# CITY OF ALBUQUERQUE

April 11, 2023

**Re: Daycare/ New Construction**  
**9101 Central Ave. NW**  
**Traffic Circulation Layout**  
Architect's Stamp 12-09-21 (K09-D002)

**1 SITE DIMENSIONS PLAN**  
SCALE: 1/16" = 1'-0"

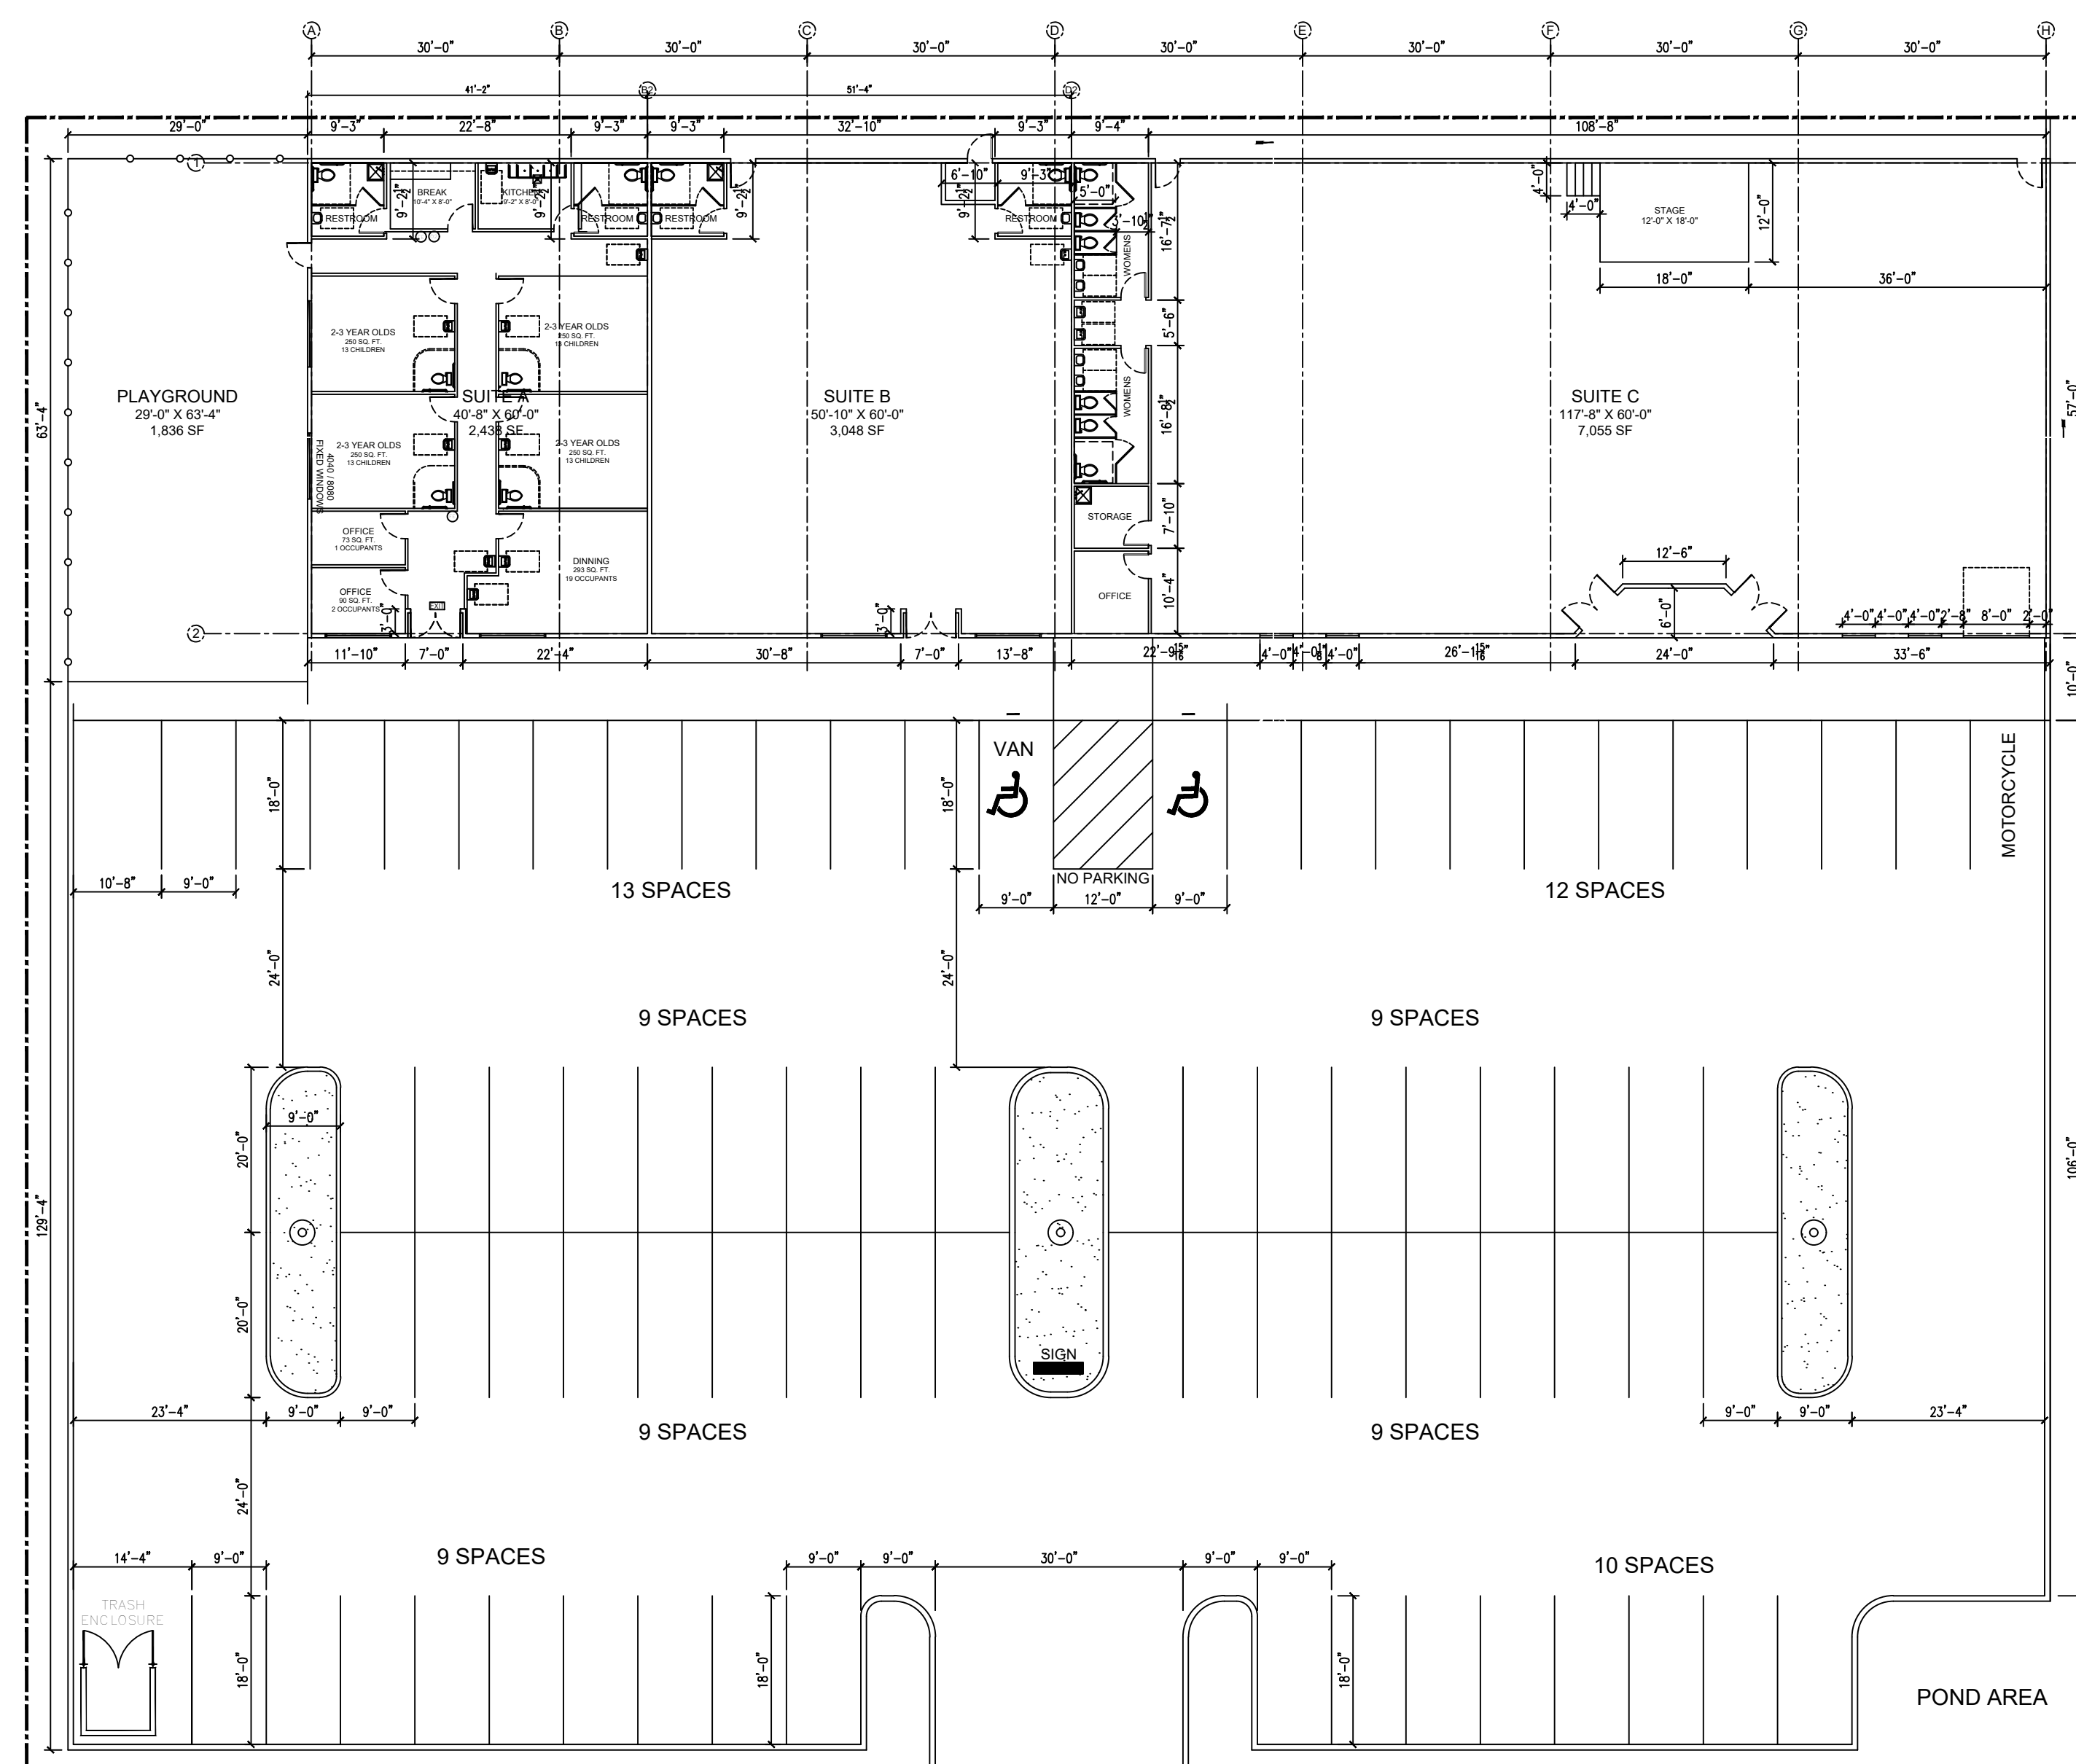
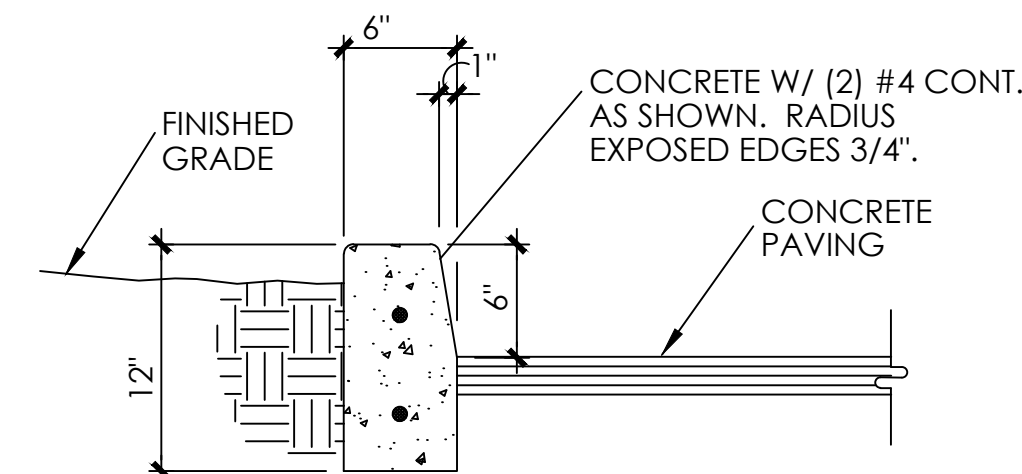
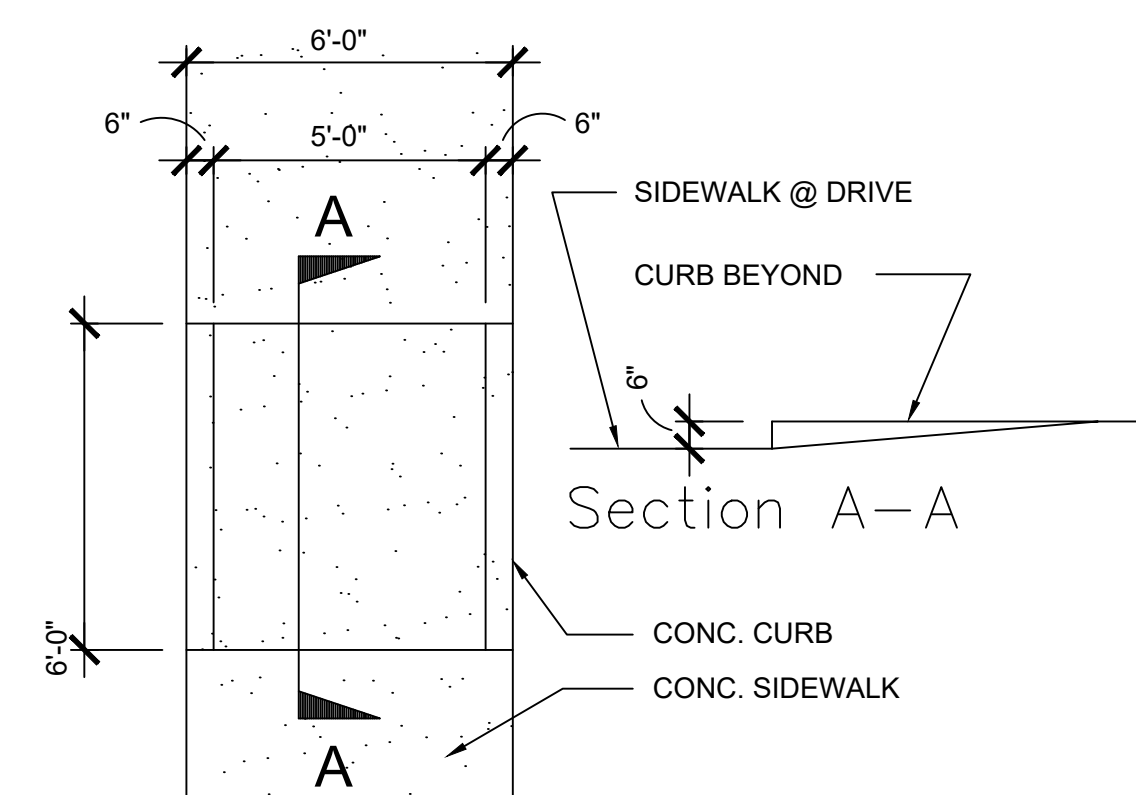
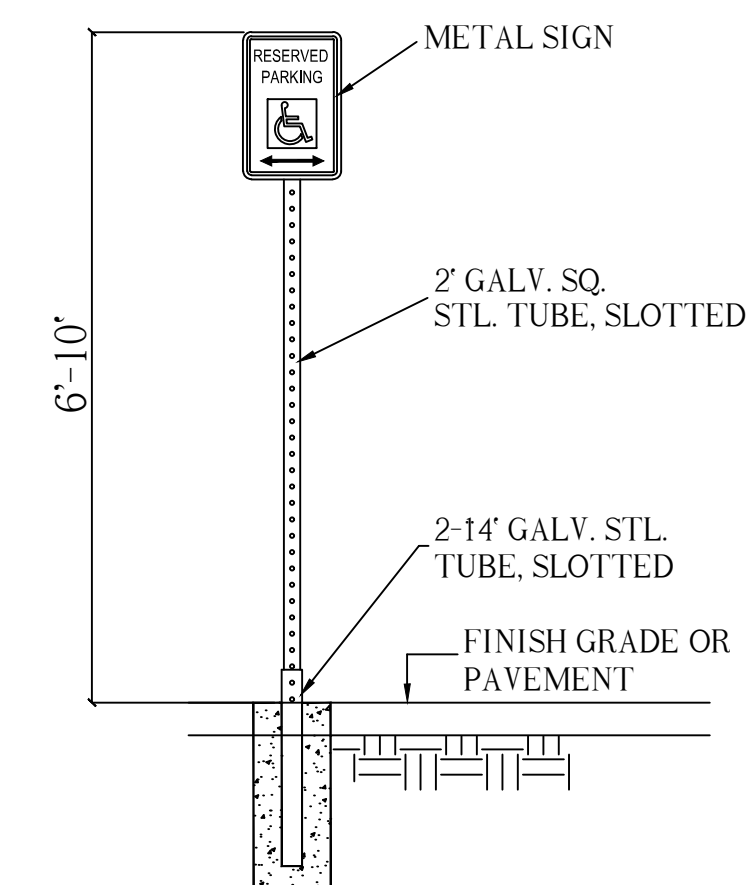
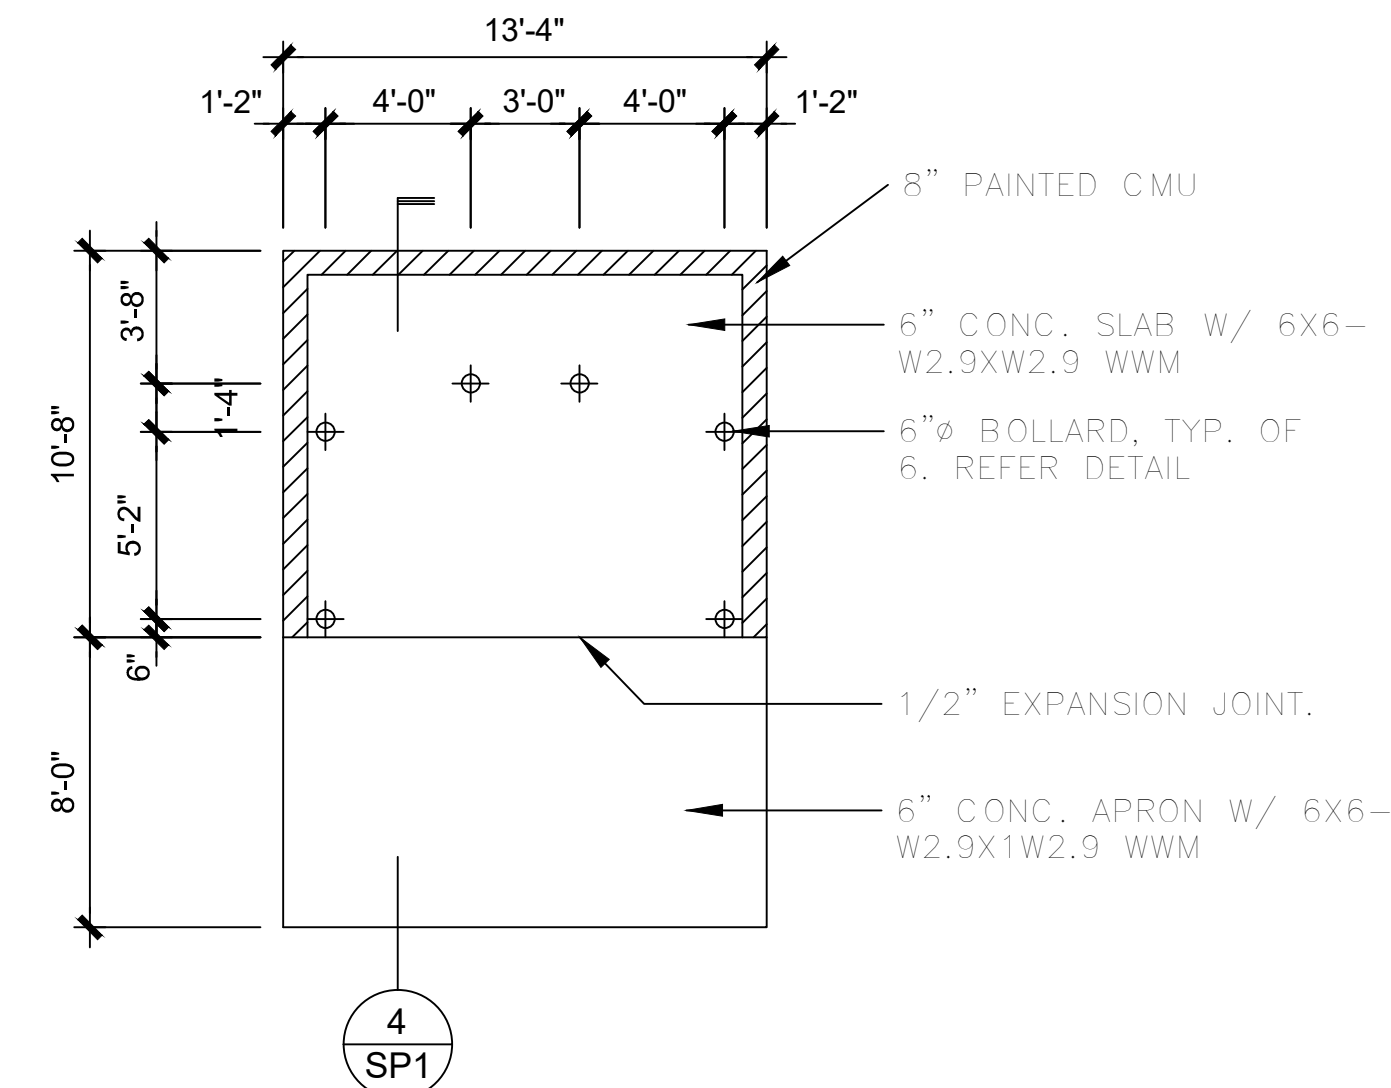
1. Please show a vicinity map showing the location of the development in relation to streets and well-known landmarks.
2. List the number of Motorcycle and Bicycle parking spaces required by the IDO.
3. Identify the right of way width, medians, curb cuts, and street widths on Central Ave NW.
4. Curb Return design is recommended for the driveway access off Central Ave.
5. Sidewalk and curb and gutter need to be build off Central Ave. from property line to property line. Reference COA std dwg 2430 & 2415A. For Sidewalk waiver please contact Ernest Armijo [earmijo@cabq.gov](mailto:earmijo@cabq.gov) at (505)-924-3991
6. Please show on the site plan the location of the shared parking Lot.
7. Please explain what is these four spaces for?

8. Please define the ADA pathways, by labeling flush or ramps. Please provide ramps details if any, and show building entrance on the site plan.
9. Curbing should be installed to delineate landscape, parking, and pedestrian ways and identify points of access. Please call out detail and location of barrier curb.

10. Parking areas shall have barriers to prevent vehicles from extending over public sidewalk, public right-of-way, or abutting lots.
11. Refuse vehicle maneuvering shall be contained on-site. The refuse vehicle shall not back into the public right of way.; provide a copy of refuse approval.

12. Provide a copy of Fire Marshal Approval.
13. It is not apparent what type of pavement surface is being proposed. A hard driving surface will be required as part of this proposed project for parking area and drive aisles.

14. Please provide a sight distance exhibit
15. Show the clear sight triangle and add the following note to the plan: "Landscaping and signage will not interfere with clear sight requirements. Therefore, signs, walls, trees, and shrubbery between 3 and 8 feet tall (as measured from the gutter pan) will not be acceptable in the clear sight triangle.

16. Please specify the City Standard Drawing Number when applicable.
17. Please remove landscape details from the TCL plan.
18. Provide notes showing what work is included and on the work order and the private work on site.
